CITY OF ALBUQUERQUE

**Re: Hartman Publishing, 8529 Indian School Road NE , Traffic Circulation
Layout
Architect's Stamp dated 4-10-13 (H20-D041)**

Based upon the information provided in your submittal received 4-11-13, the above referenced plan cannot be approved for Building Permit until the following comments are addressed:

TCL.01

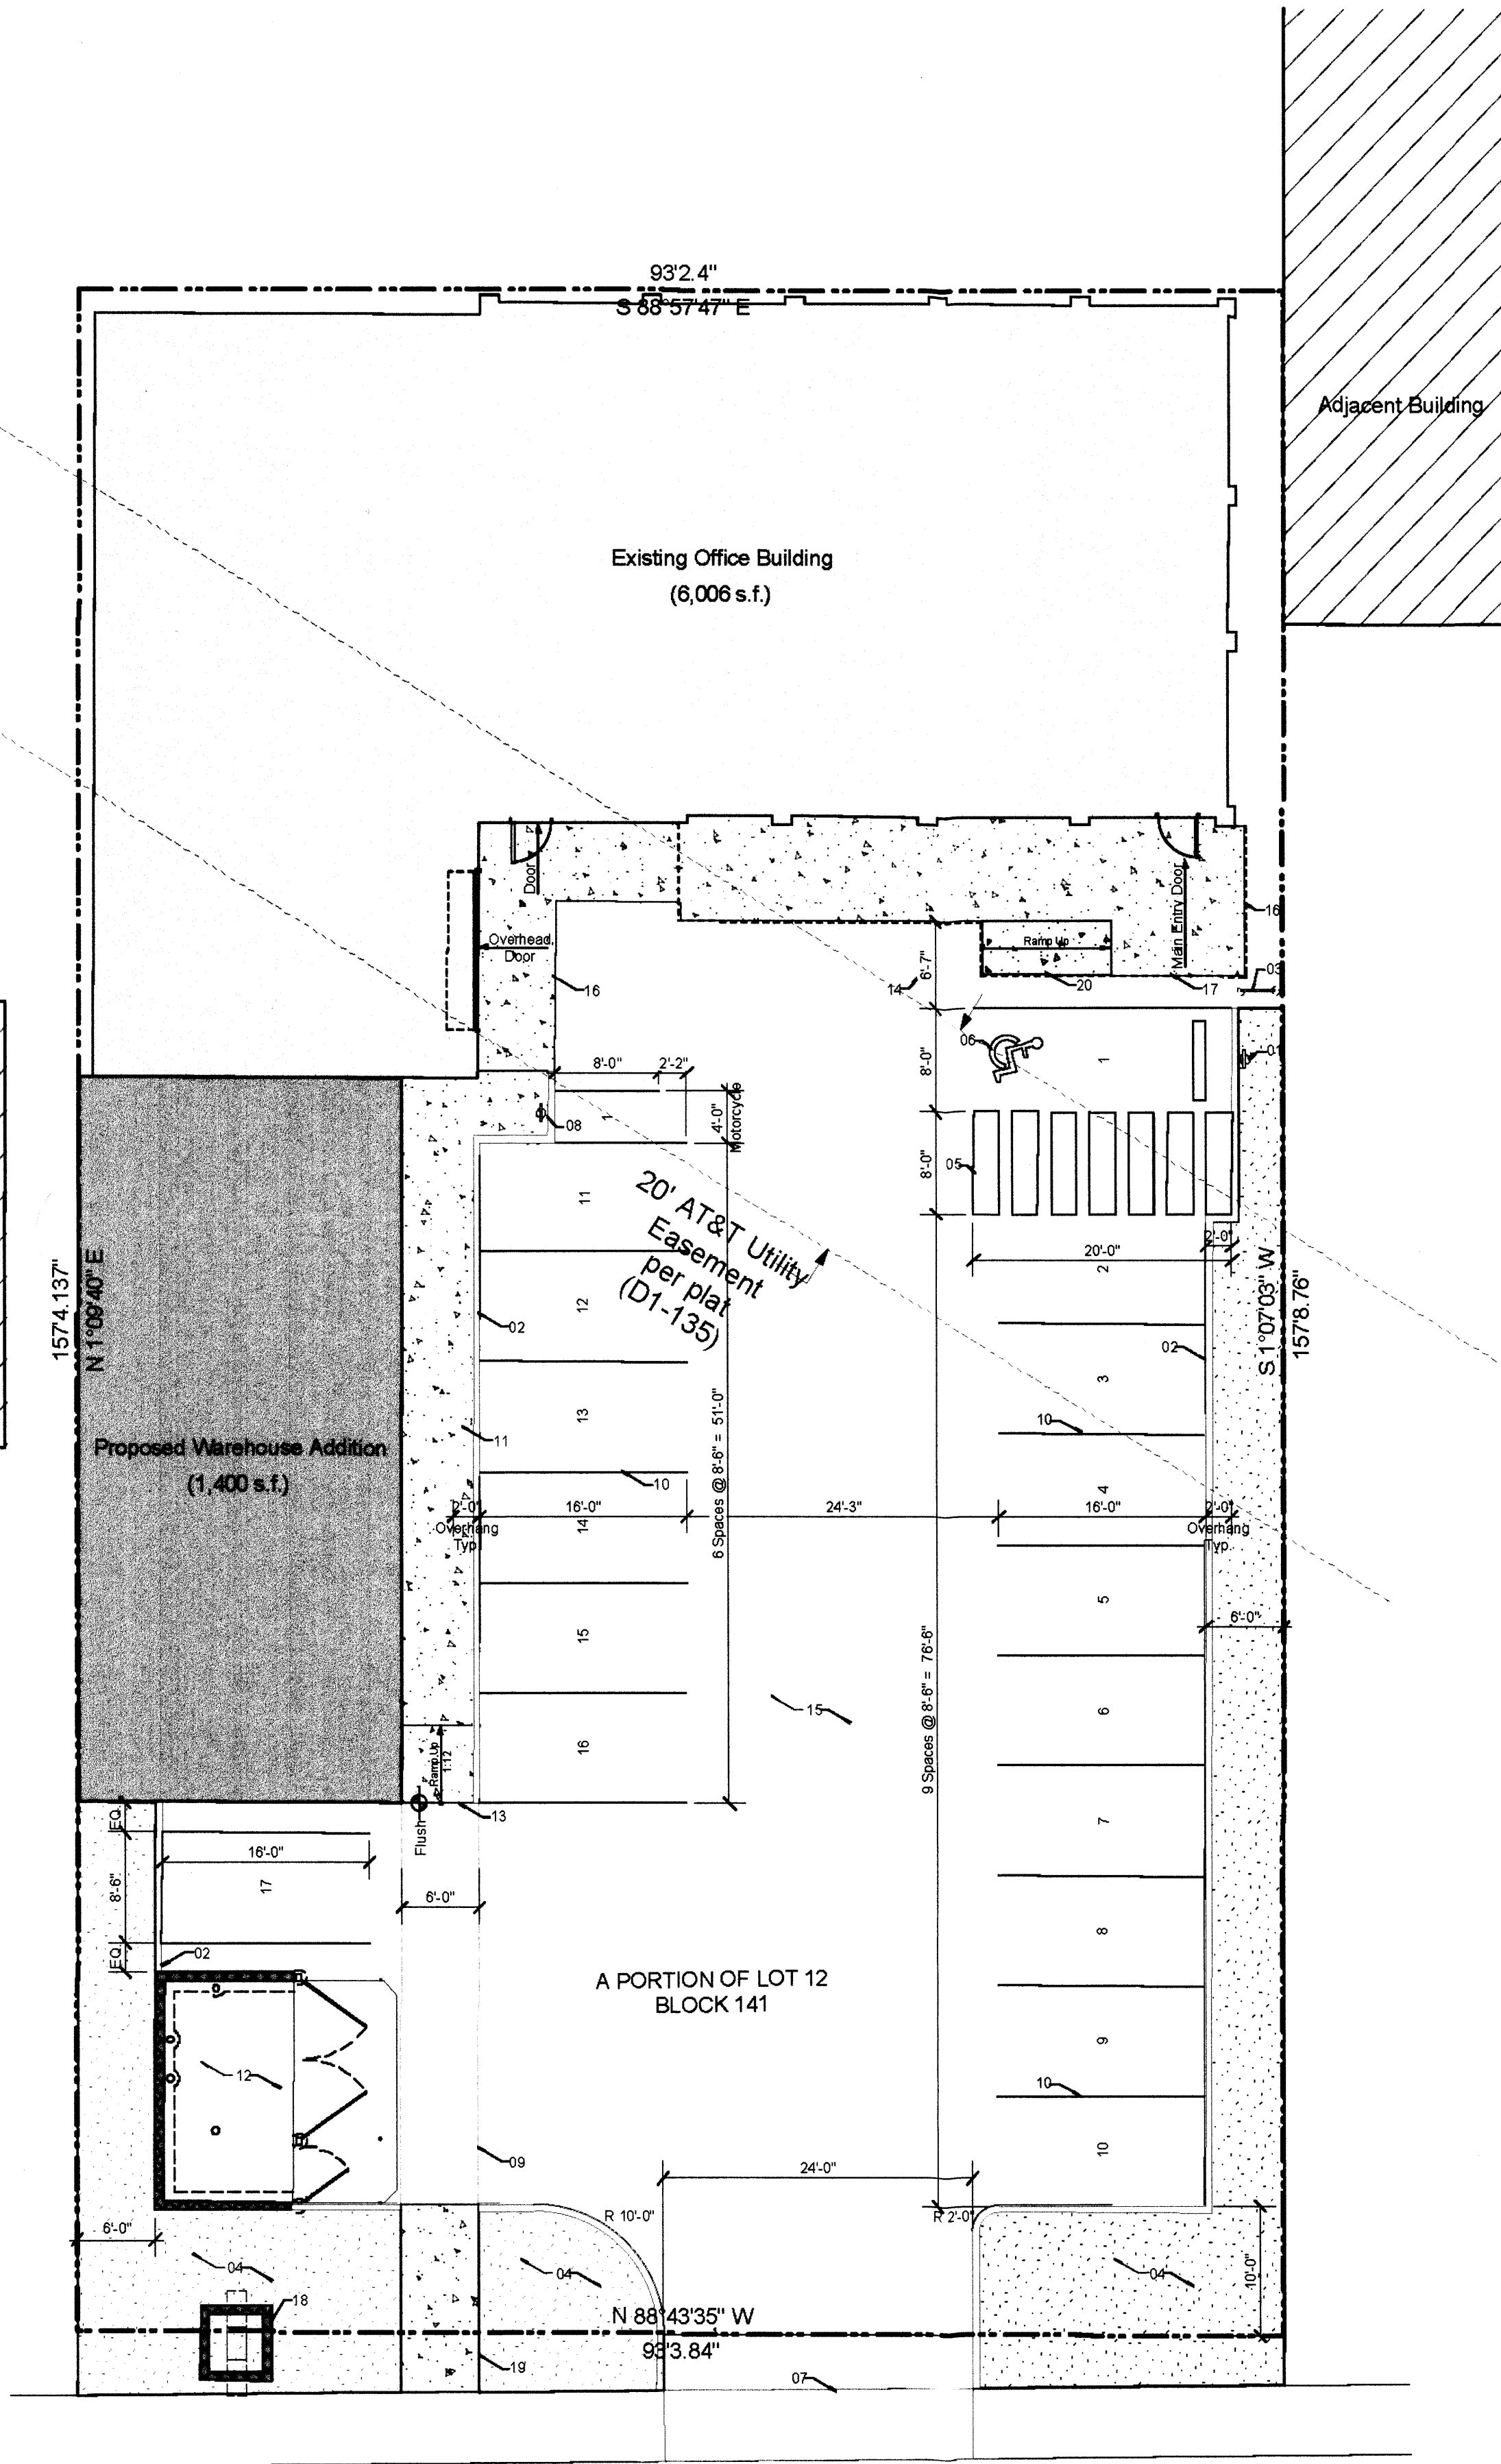
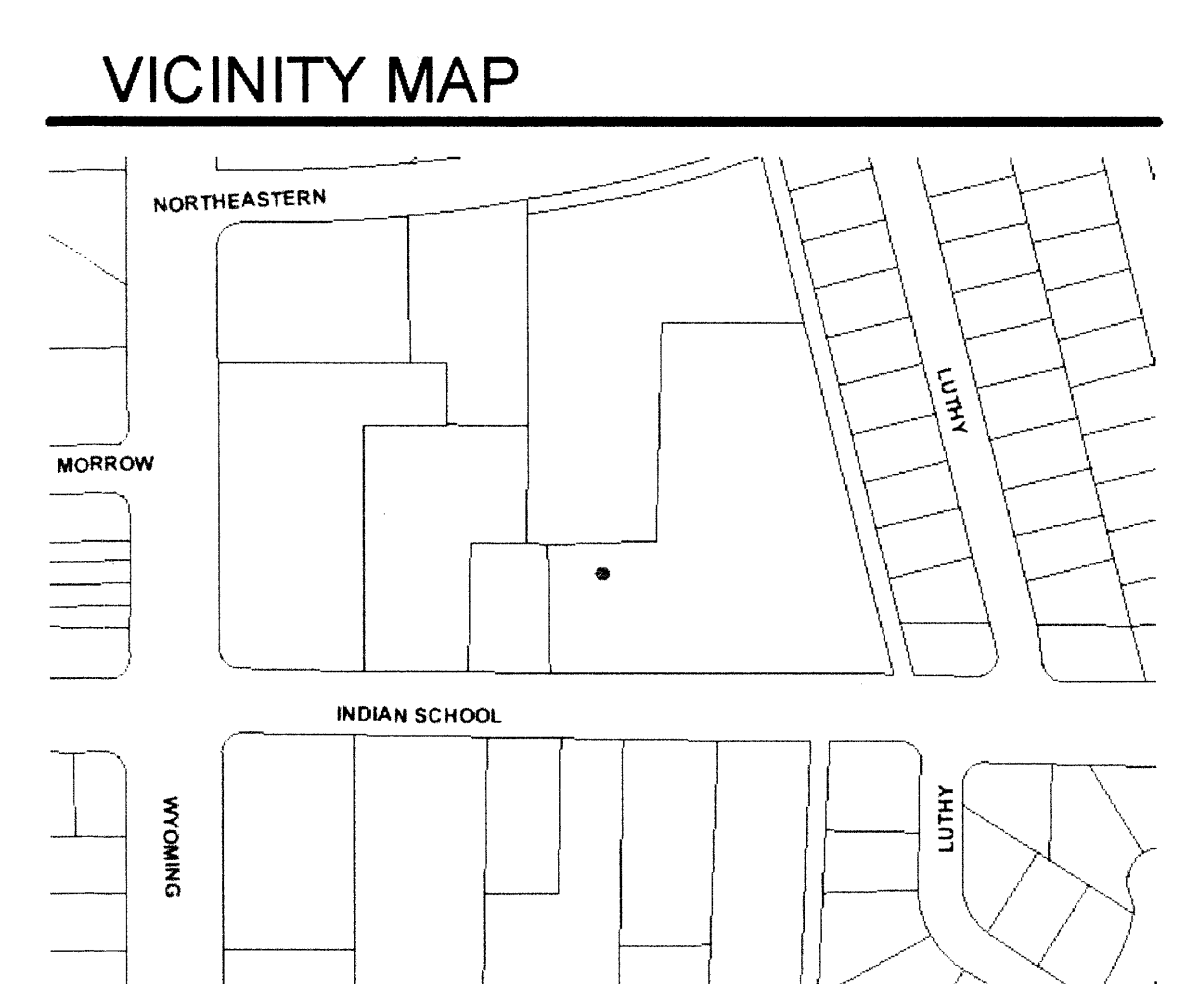
1. Please refer to all applicable city standards.
2. Please ensure all ramps are ADA compliant.
3. List the width of the existing drivepads.
4. Define width of the existing sidewalk.

5. Any abandoned or unused drivepads must be removed and replaced with City of Albuquerque (COA) standard designs for curb, gutter and sidewalk. Please label site plan accordingly, including standard drawings or provide details.

6. Since Indian School Rd is an arterial roadway, driveways with right in / right out only have a minimum driveway width of 30 feet (see the *Development Process Manual*, Chapter 23, Section 6, Part B.8).

7. If the site has left turn access, the drivepad has a 36-foot minimum width.
8. Please label and detail the proposed driveway.
9. Show a detail of the wheelchair ramps located at the proposed driveway, or refer to the appropriate city standard.

10. The turn-out radius recommended is 25 ft to accommodate refuse truck and for access to / from arterial roads.
11. Work within the public right of way requires a work order with DRC approved plans.

12. The existing pylon sign may interfere with the sight distance of the intersection. Please provide a sight distance exhibit (see the *Development Process Manual*, Chapter 23, Part B, Section 5.a).

13. The existing sign appears to be located within the COA ROW. Is there a COA Revocable Permit for this sign?

14. According to COA AGIS, the site's western property line extends beyond the limits provided by the TCL. Please clarify.
15. Please include a copy of your shared access agreement with the adjacent property owner if the site does in fact share access.
16. Please provide details of the existing ramp (keyed note 20) to ensure it is ADA compliant.
17. Parking stalls providing 16 foot lengths with a 2 foot overhang must comply with the DPM. A six foot unobstructed ADA accessible pedestrian pathway must be provided from the COA ROW to the buildings entrance. Additionally, vehicles can not overhang vegetative landscaping.
18. The pedestrian connection, key note 19, does not indicate pavement marking on asphalt to connect sidewalks. Please clarify.
